re: Geotechnical Review of Grading Plans
Proposed School Development
620 Triangle Street – Ottawa, Ontario
to: Ottawa Catholic School Board – Donald Wood – donald.wood@ocsb.ca
date: September 17, 2025
file: PG7249-MEMO.03

Grading Plan Review

- ☐ Grading Plan, DWG No: 24093-GR1, Project No. 24093 for the Ottawa Catholic School Board, dated March 2025

DWG. No.
24093-GR1

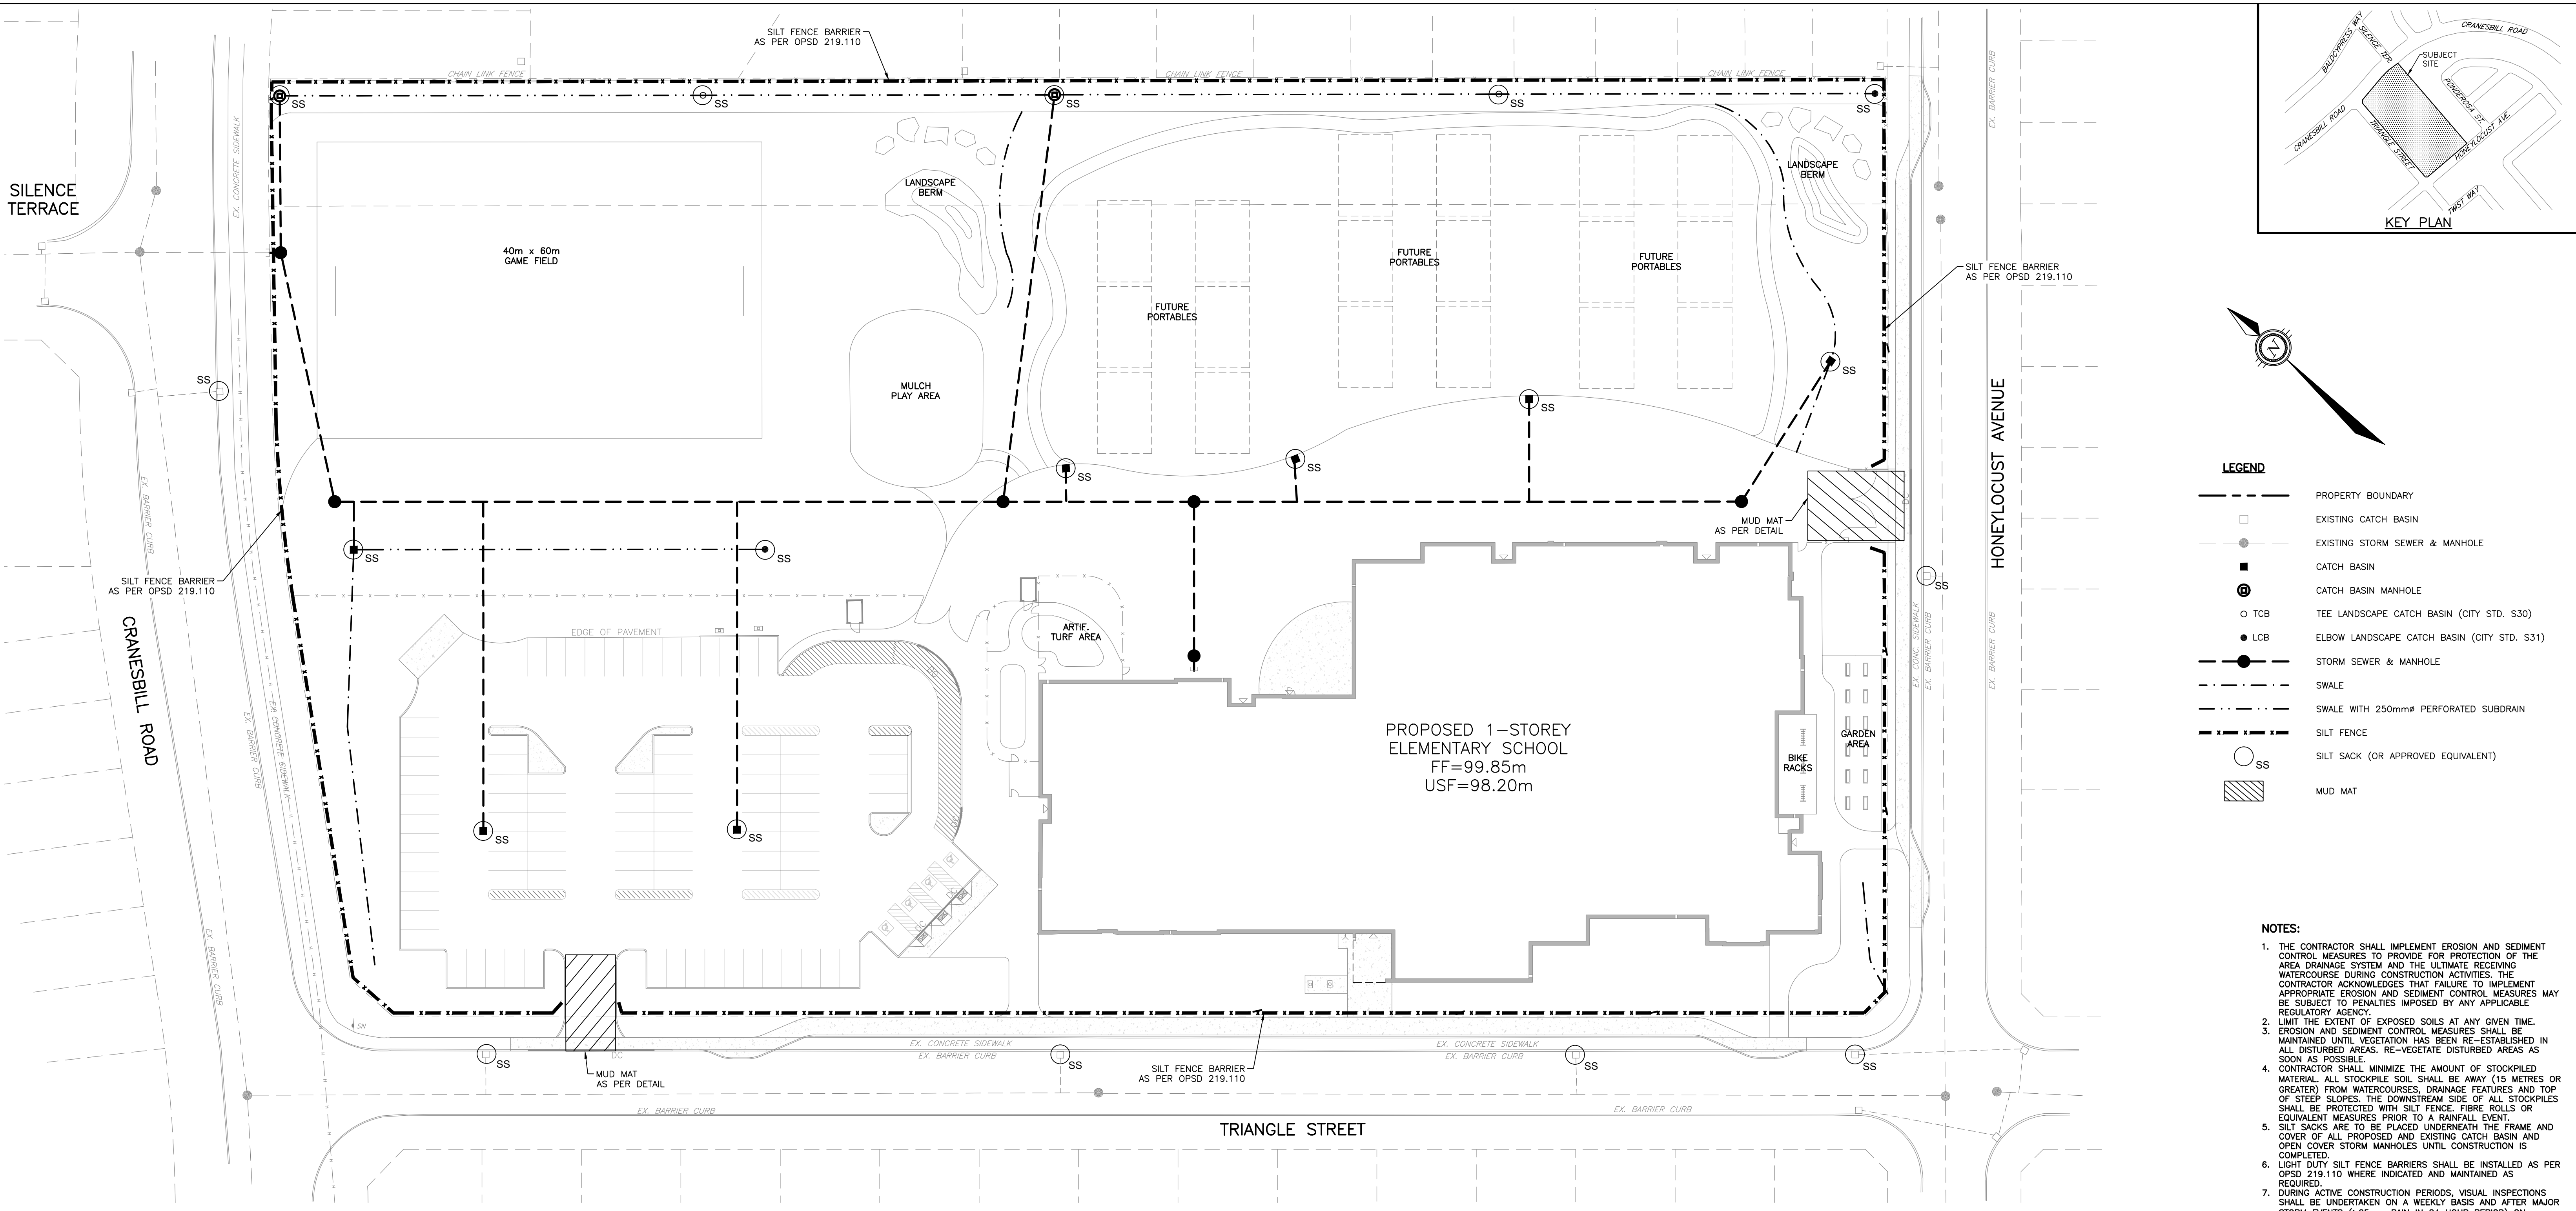
Based on our review of the above-noted drawing, the proposed grades throughout the subject site are generally within the permissible grade raise restriction of 1.8 m provided in the aforementioned geotechnical investigation report.

Therefore, the proposed grading is considered acceptable from a geotechnical perspective such that lightweight fill (LWF) or any further measures will not be required to be taken for the proposed development.

Further, sufficient soil cover will have to be provided to perimeter and exterior pad footings if the use of insulation to mitigate the migration of frost will not be required for the subject footings. This may be confirmed at the time of detailed design.
